Attention Director Infrastructure Projects,
Planning Services Department of Planning and Environment
Application number SSI 6307 (Westconnex M4 East).
GPO Box 39 Sydney NSW 2001

Please find below my submission on the M4 East Environmental Impact Statement regarding:

Health Risk Assessment:

Figure 10 Noise barriers in the study area

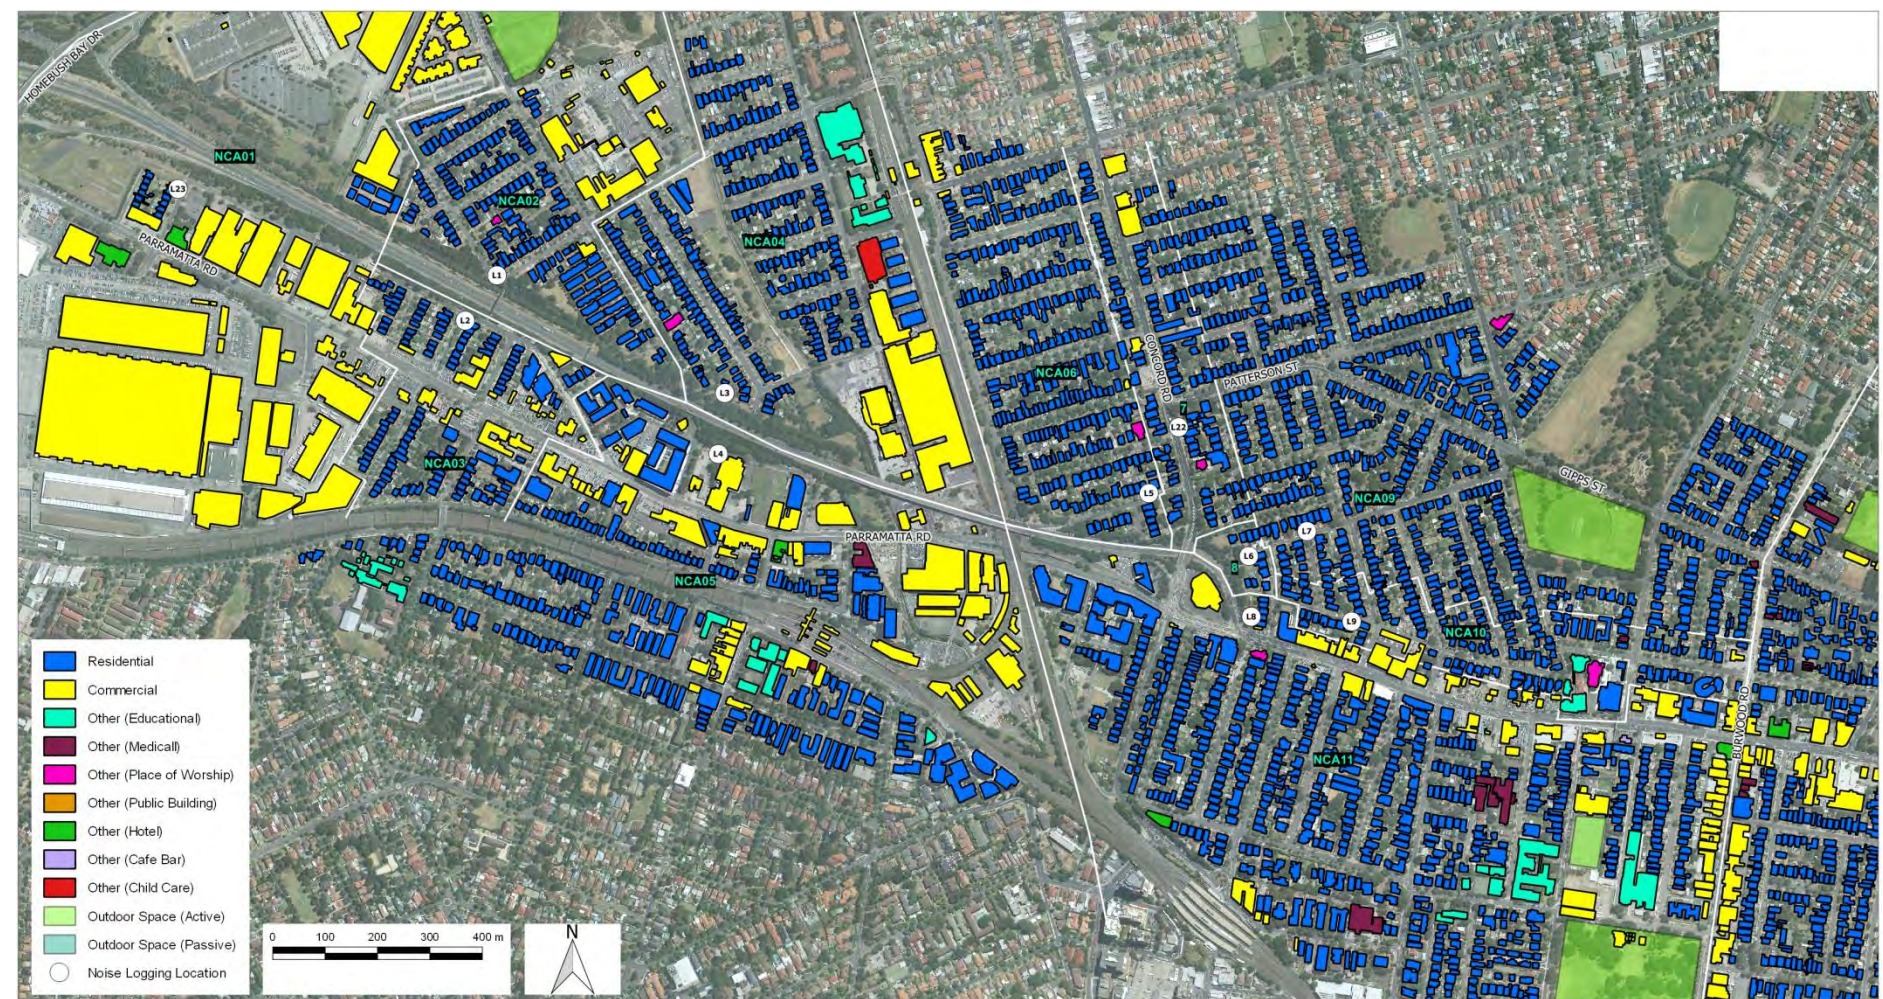
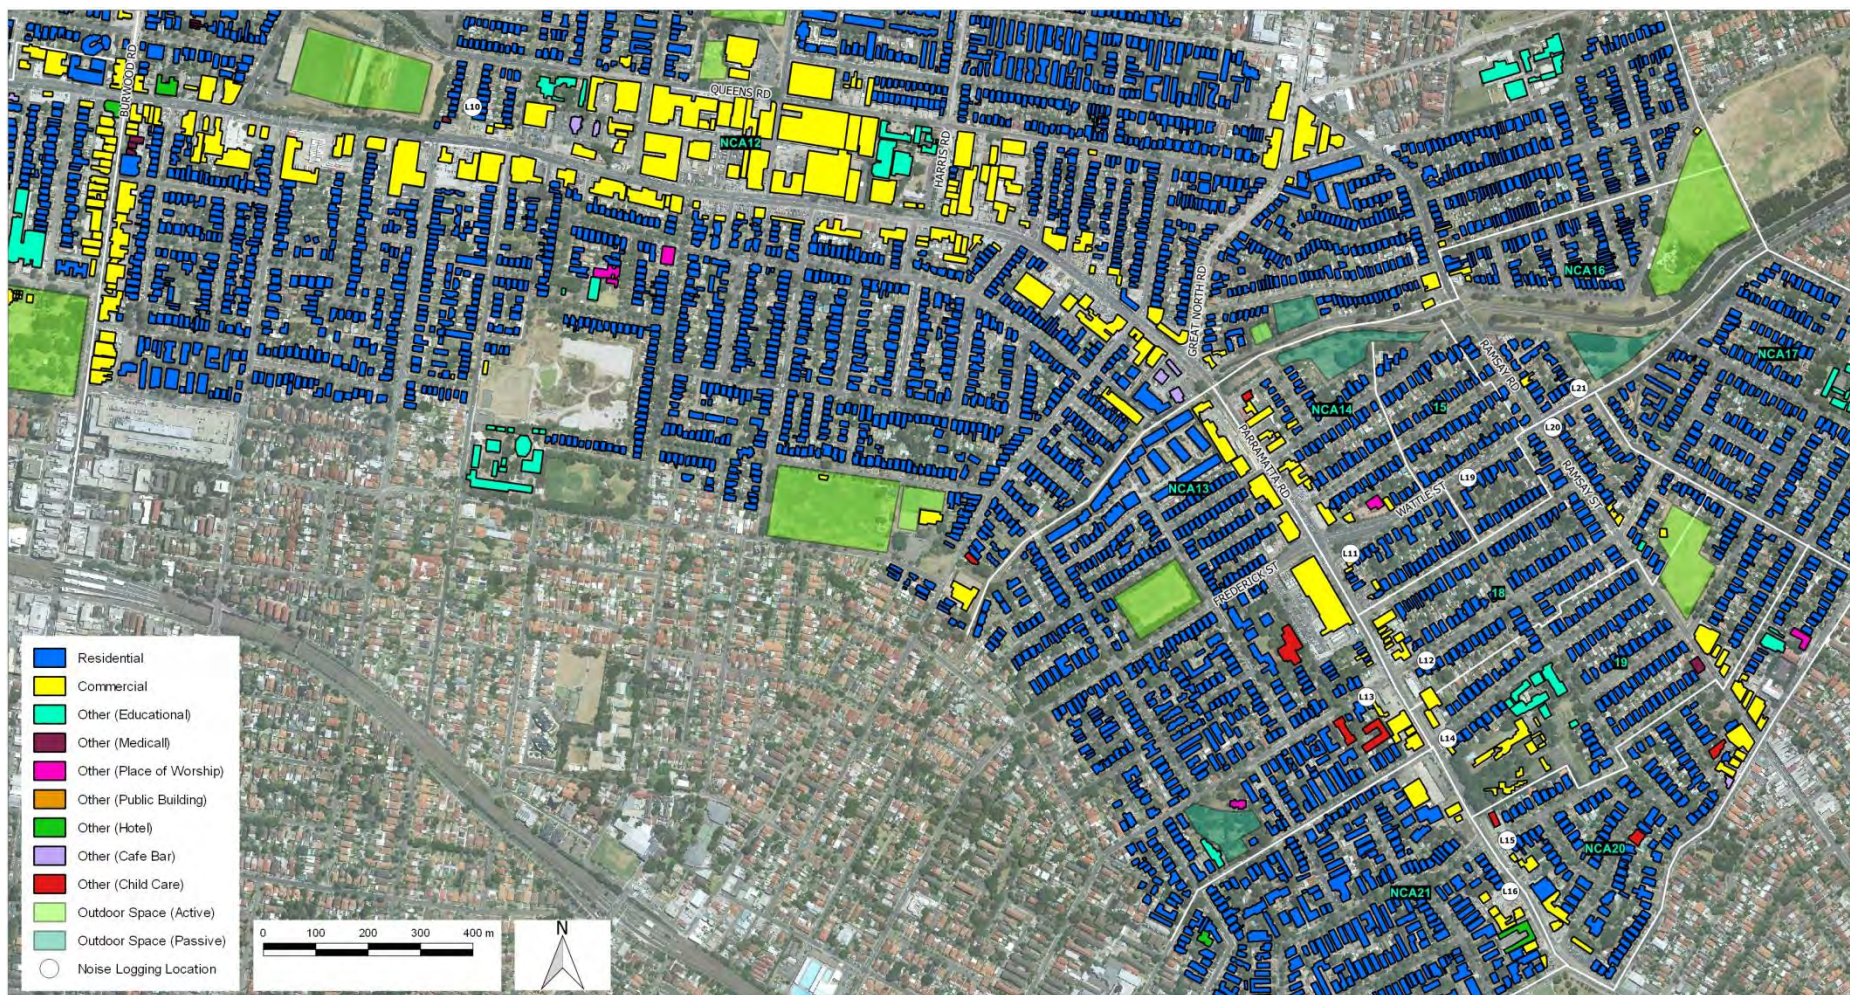
4.2 There does not appear to be any noise barrier provision on Sydney street or Carrington Lane following completion of construction. We request that consideration be made for inclusion of sound barriers at these sites.
